Appeal Decision

Appeal Ref: APP/R5510/W/21/3275115

68-76 Albert Road, West Drayton, UB7 8ES

- The appeal is made under section 78 of the Town and Country Planning Act 1990 against a refusal to grant approval required under Schedule 2, Part 20, Class A of the Town and Country Planning (General Permitted Development) Order 2015 as amended.
 - The appeal is made by Mr H Purewal, Purewal Property Ltd against the decision of London Borough of Hillingdon.
 - The application Ref 33654/APP/2020/2582, dated 19 August 2020, was refused by notice dated 17 November 2020.
 - The development proposed is creation of two additional floors above existing building to incorporate 4 x 1-bed flats (Prior Approval).
-

PROPOSED 3/F (1:100)

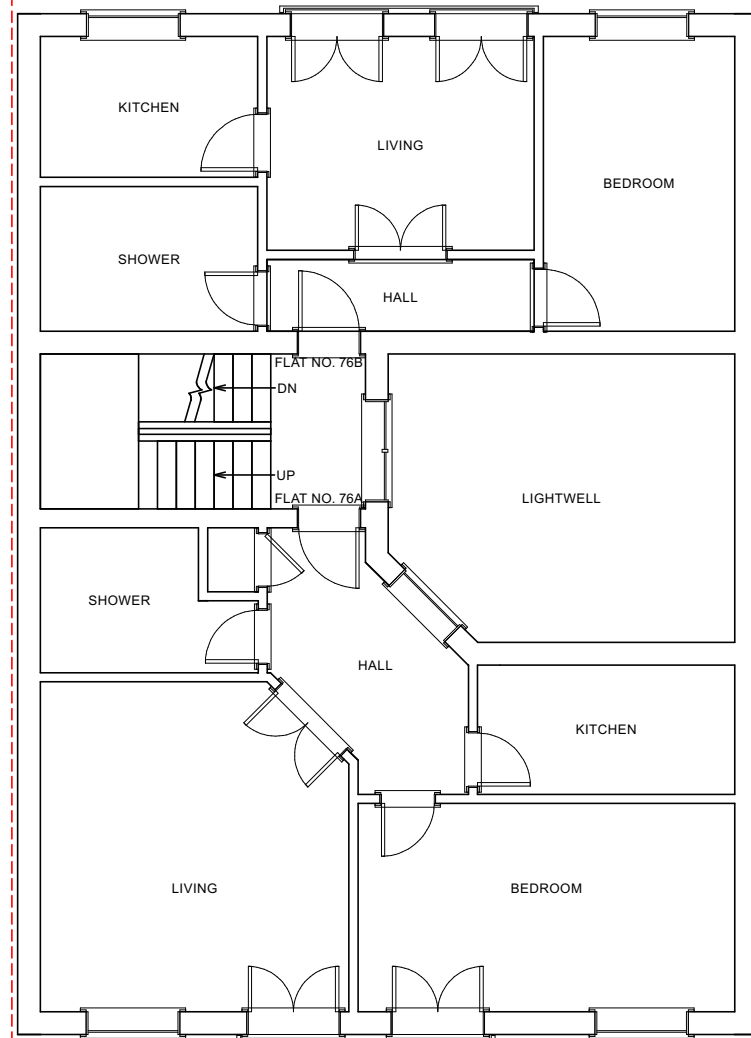
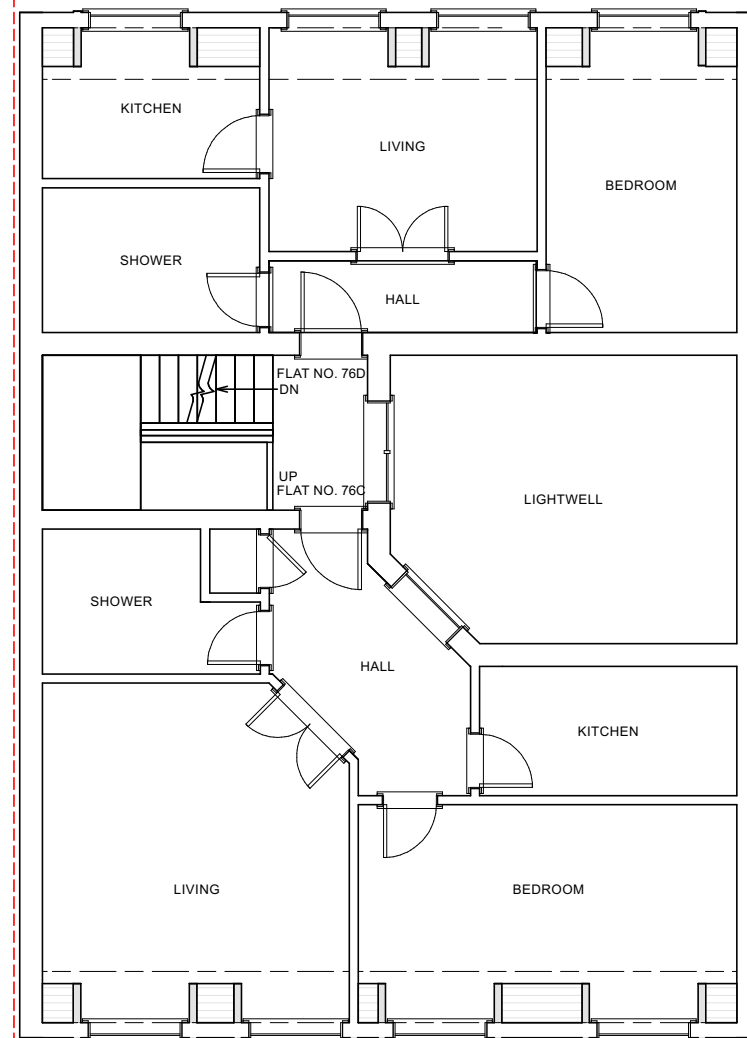
17. Two of the proposed flats would not have windows to their kitchens. For the purposes of Schedule 2 Part 20 of the GPDO 'habitable rooms' is defined as meaning 'any rooms used or intended to be used for sleeping or living which are not solely used for cooking purposes, but does not include bath or toilet facilities, service rooms, corridors, laundry rooms, hallways or utility rooms'. On this basis the small kitchens proposed would not count as habitable rooms. Adequate daylight would be available in the other rooms of the two flats and the situation would not be dissimilar to some of the other flats in the building. I conclude that adequate natural light would be available for future occupiers of the proposed flats.

PROPOSED SIDE (1:100)

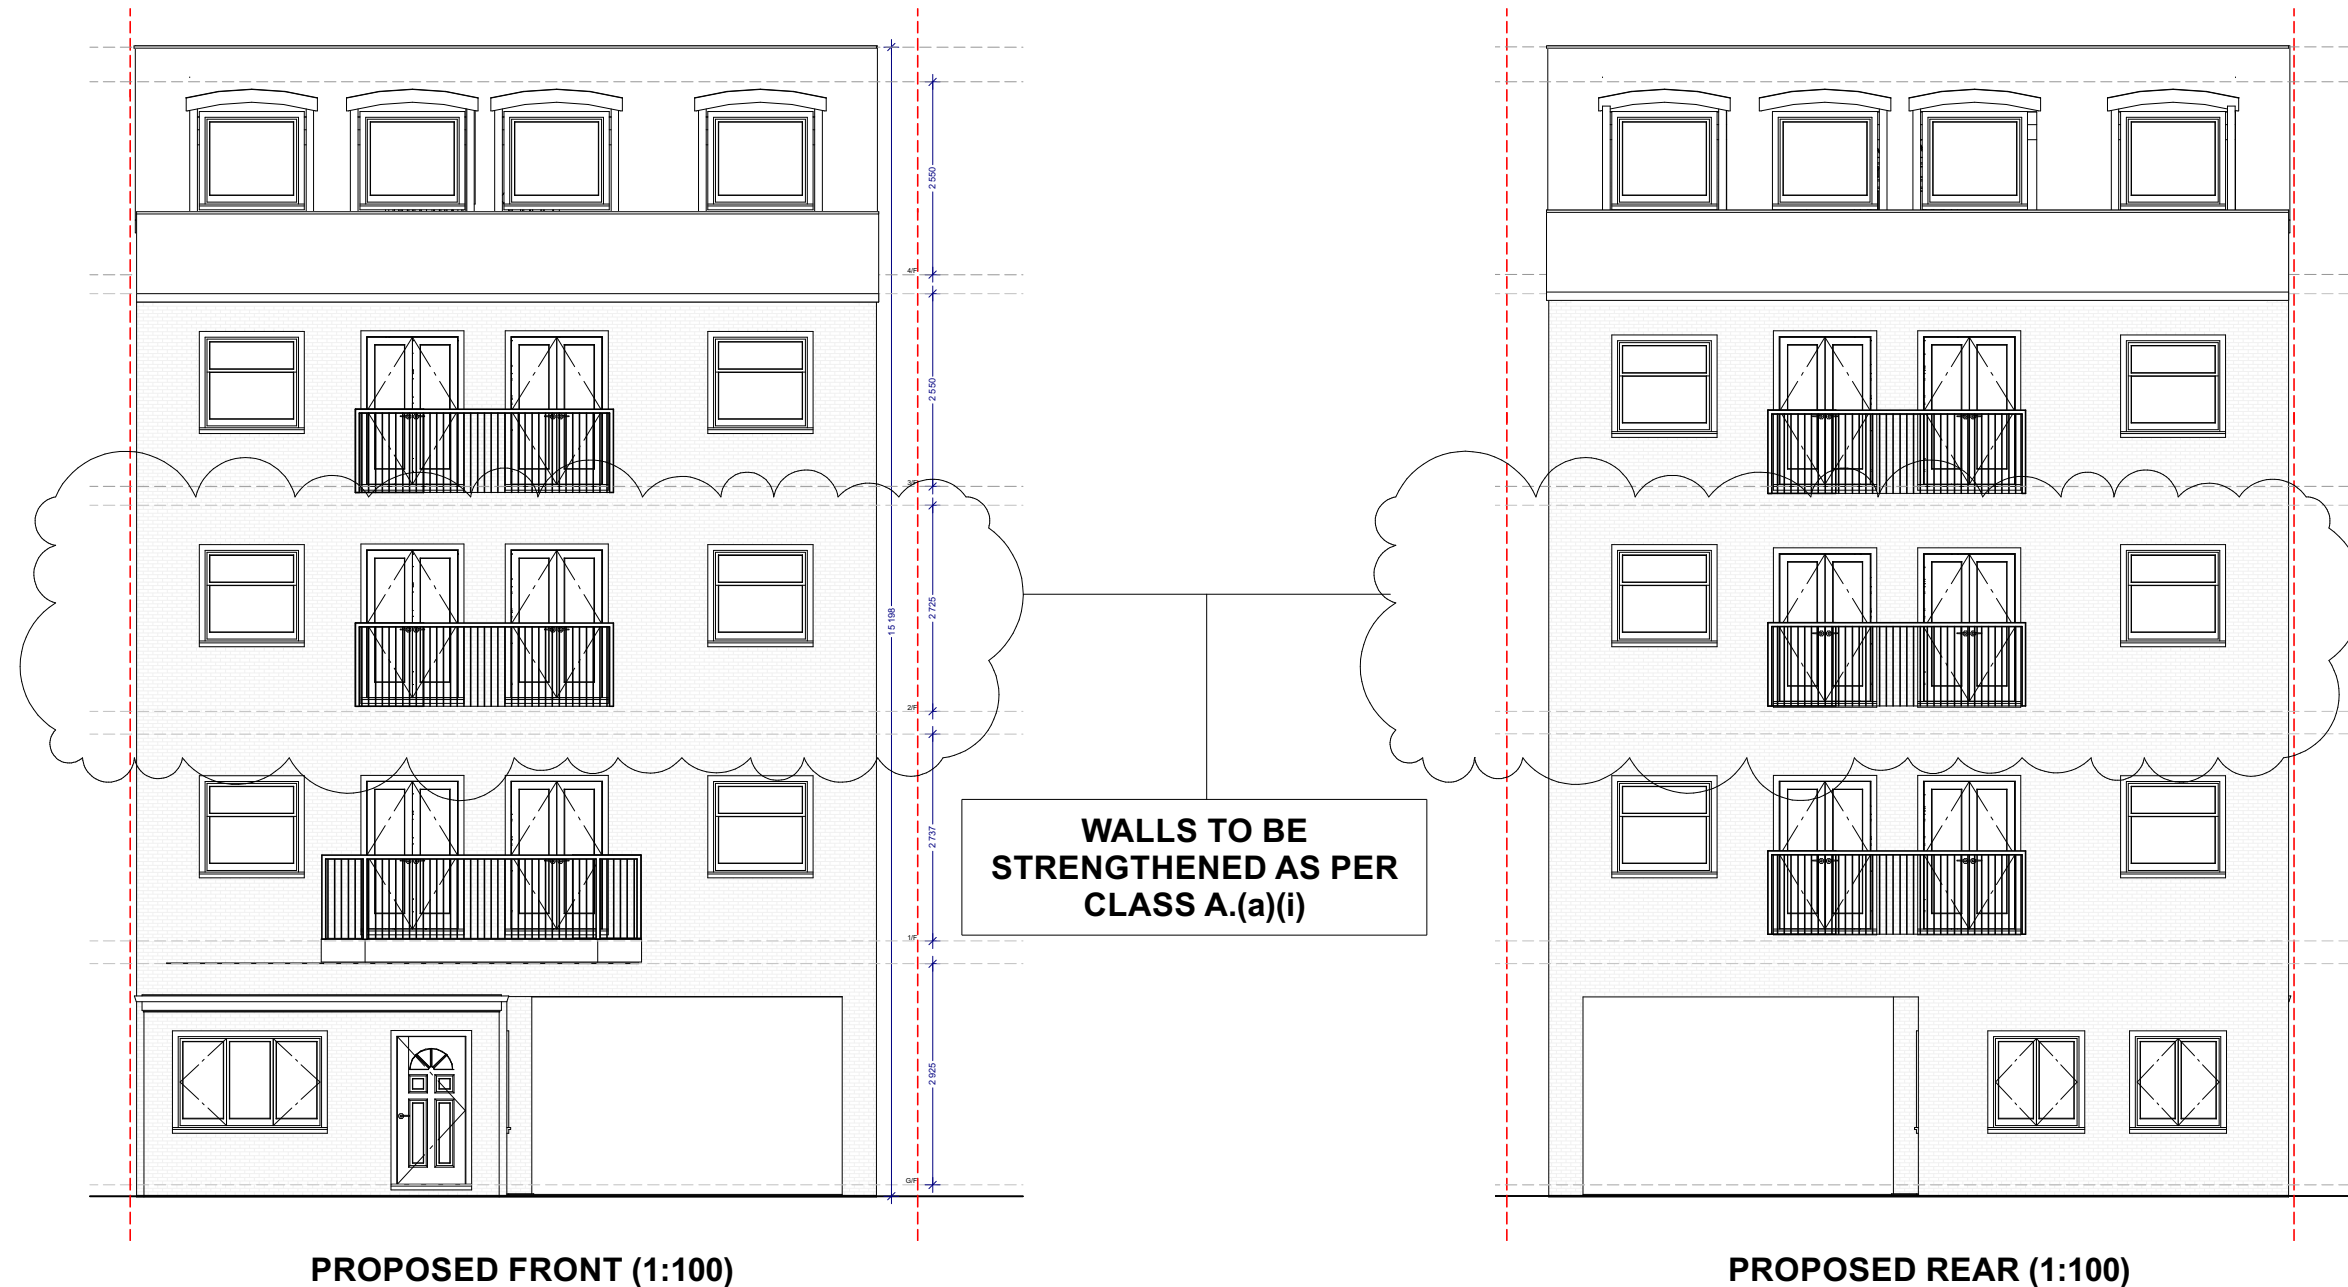
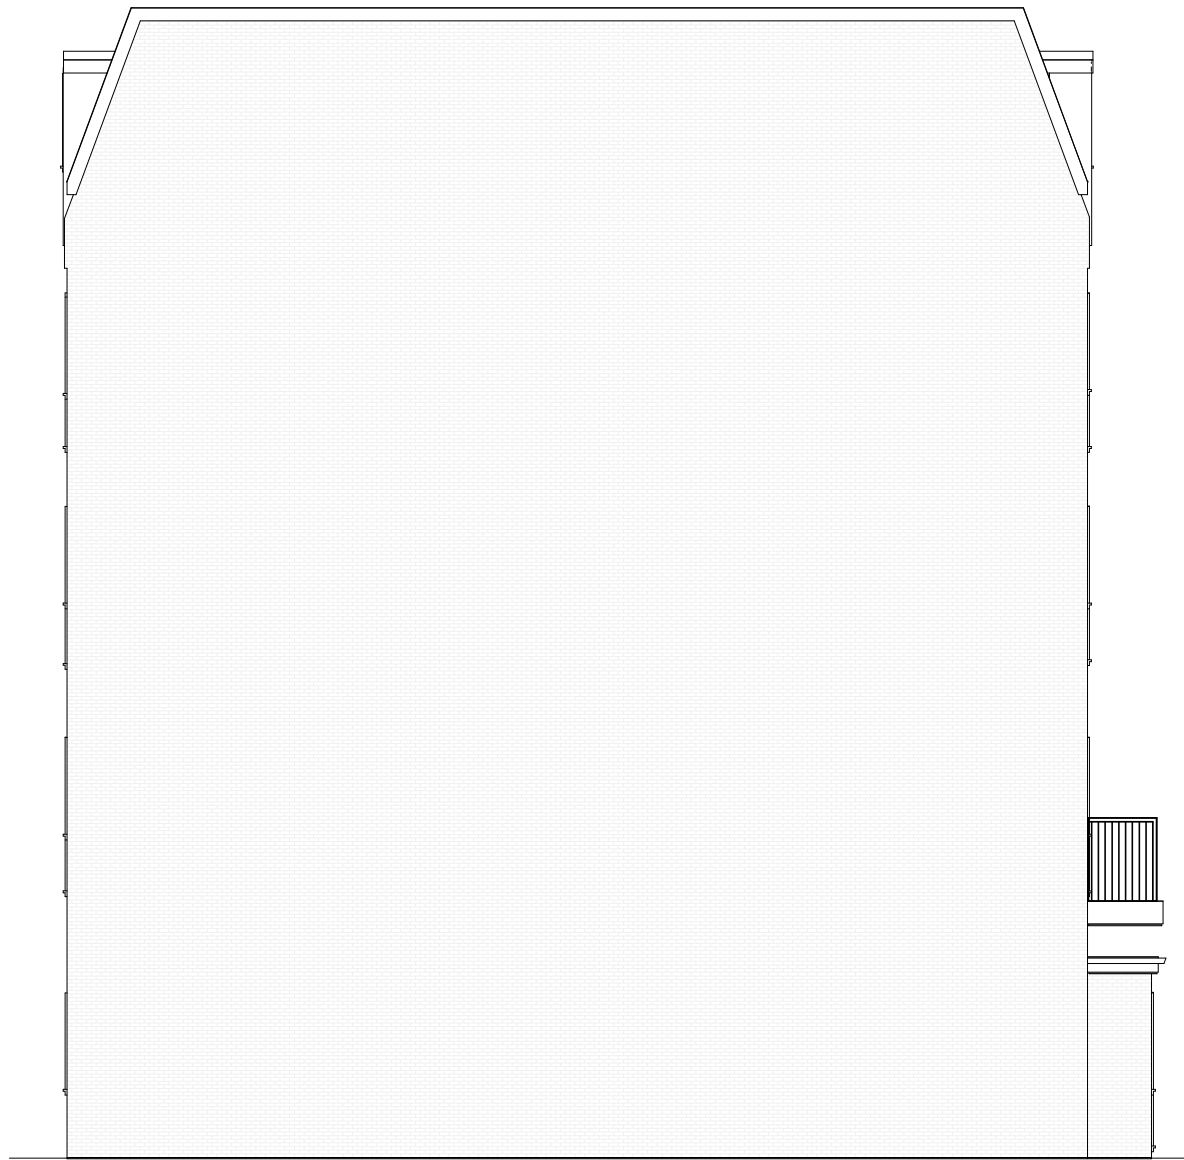
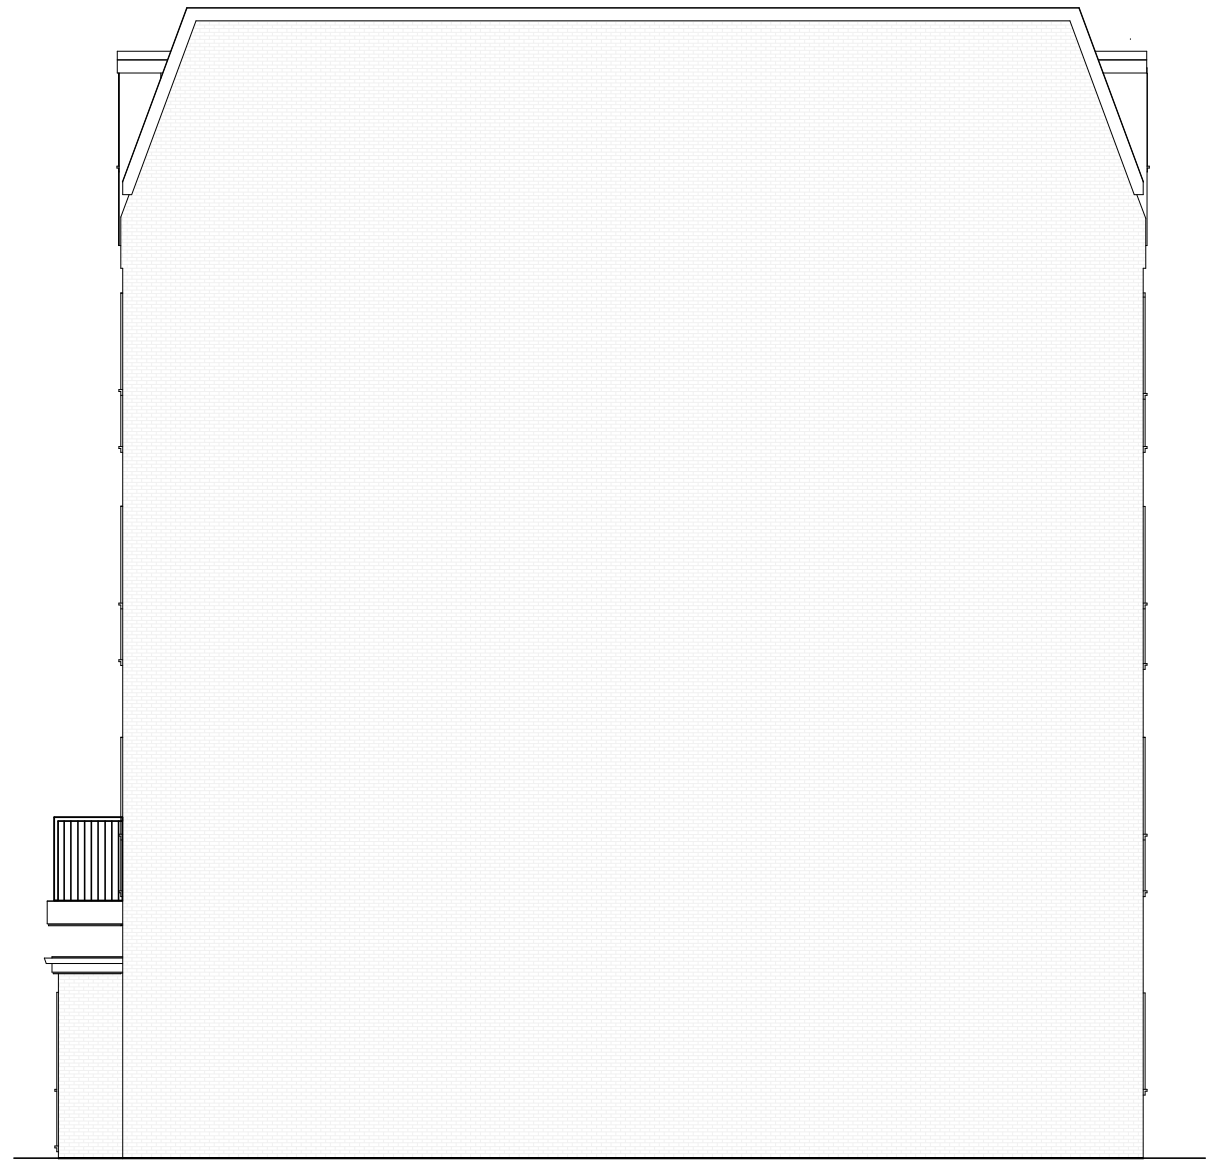
16. The proposed building would repeat the existing design in terms of materials roof shape and fenestration. However, although the building is detached, it has very narrow gaps between it and the neighbouring properties. As a result the proposed addition of two floors would result in an awkward, disjointed and incongruous building form projecting well above the roofs of the adjacent buildings. It would also be out of scale with the houses when viewed along the rest of Albert Road whether or not it would be intrusive in views from Fairfield Road or Norton Road. In my judgement the proposal would therefore cause unacceptable harm to the street scene.

PROPOSED PARKING AND CYCLE STORAGE (1:200)

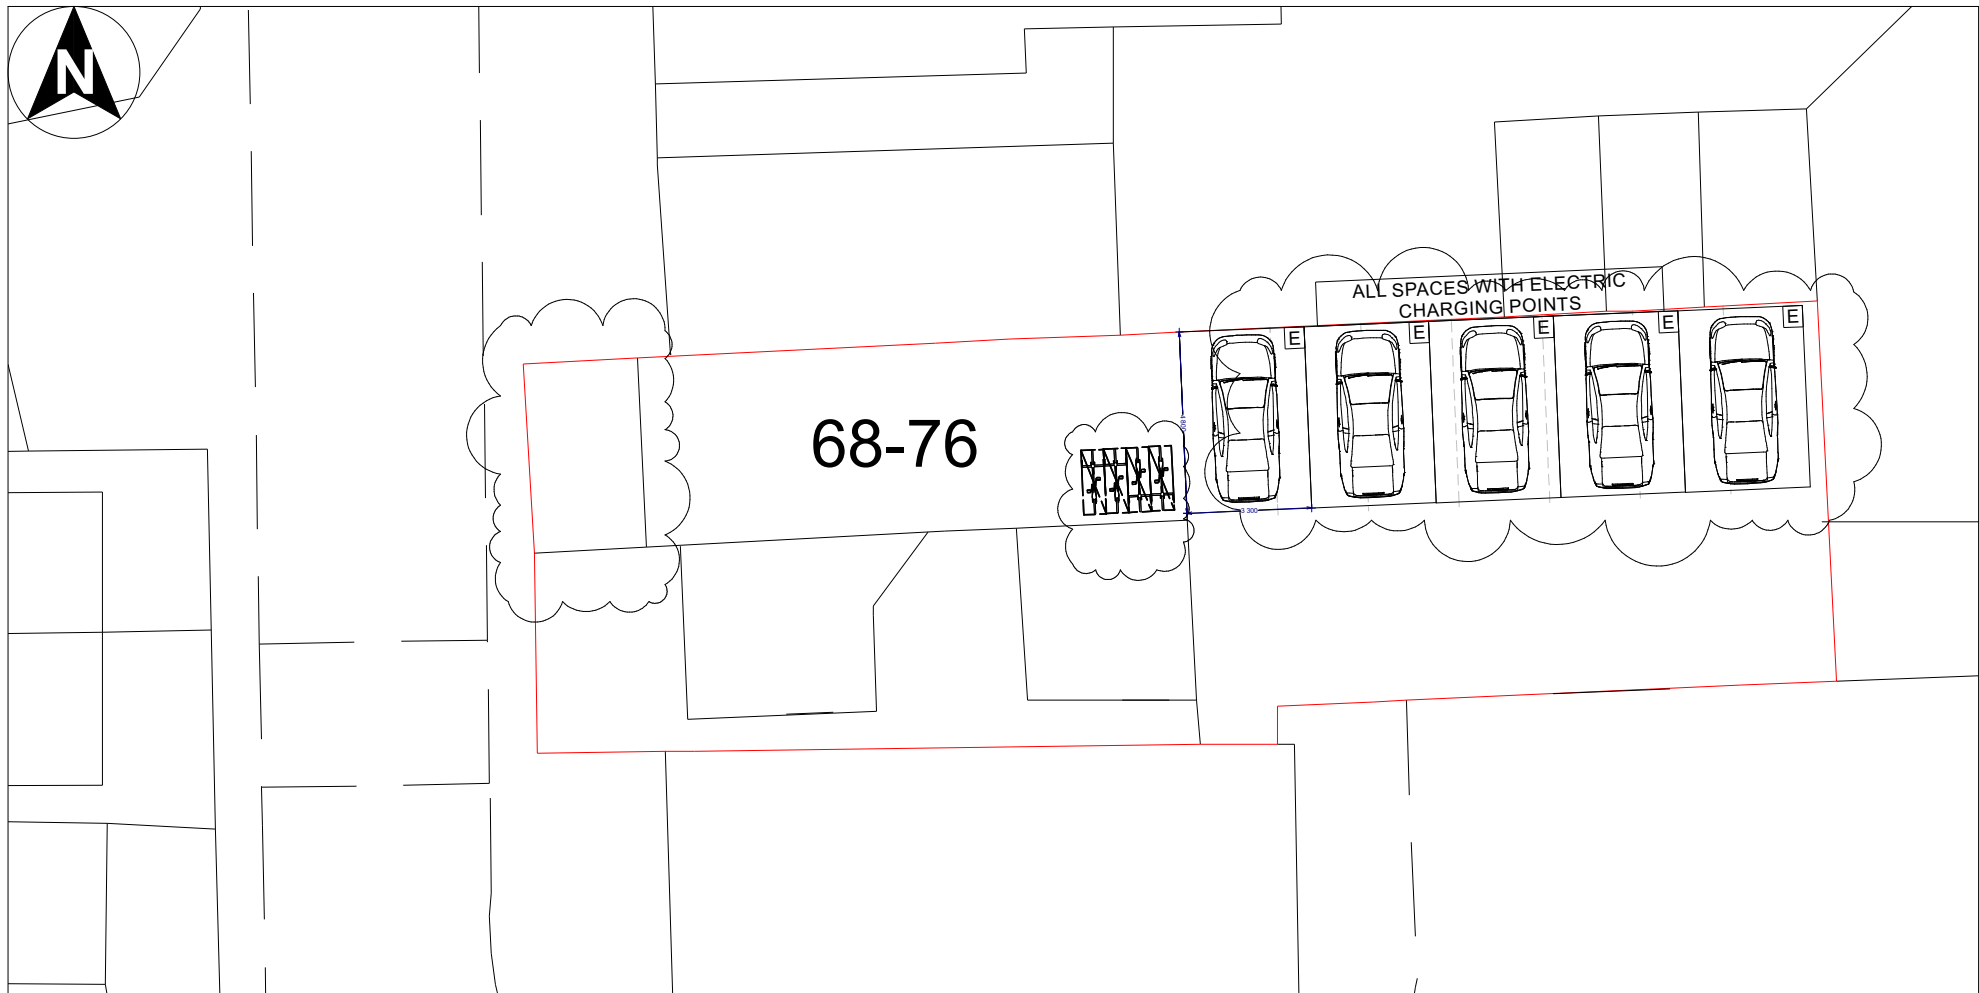
5. The appeal is accompanied by a Highways Planning Ltd Statement and a revised plan Ref 2020-68-76AR-APL-1 Rev 01C in respect of car parking arrangements, electric vehicle charging and cycle storage; and Plan Ref 21.63-001 showing swept path plots. These amendments do not so alter the scheme that it would unacceptably prejudice the interests of the Council or other Parties. Accordingly I have determined the appeal on this basis.

8. There is a parking area to the rear of the building although spaces are not marked out. The Council is concerned that the proposal would lead to on street parking to the detriment of the safety of highway users and exacerbating parking stress. The Council considered that 7 car parking spaces for a total of 9 flats, as originally proposed, would be enough numerically, but objected because of the restricted manoeuvring space. The amended plan shows 5 car parking spaces, and the swept path plots show that vehicles could be turned so as to exit the site in forward gear.

11. The amended plan provides for electric vehicle charging points for each car parking space and cycle parking for the four proposed flats in an existing storage room on the ground floor. These could be secured by planning conditions.
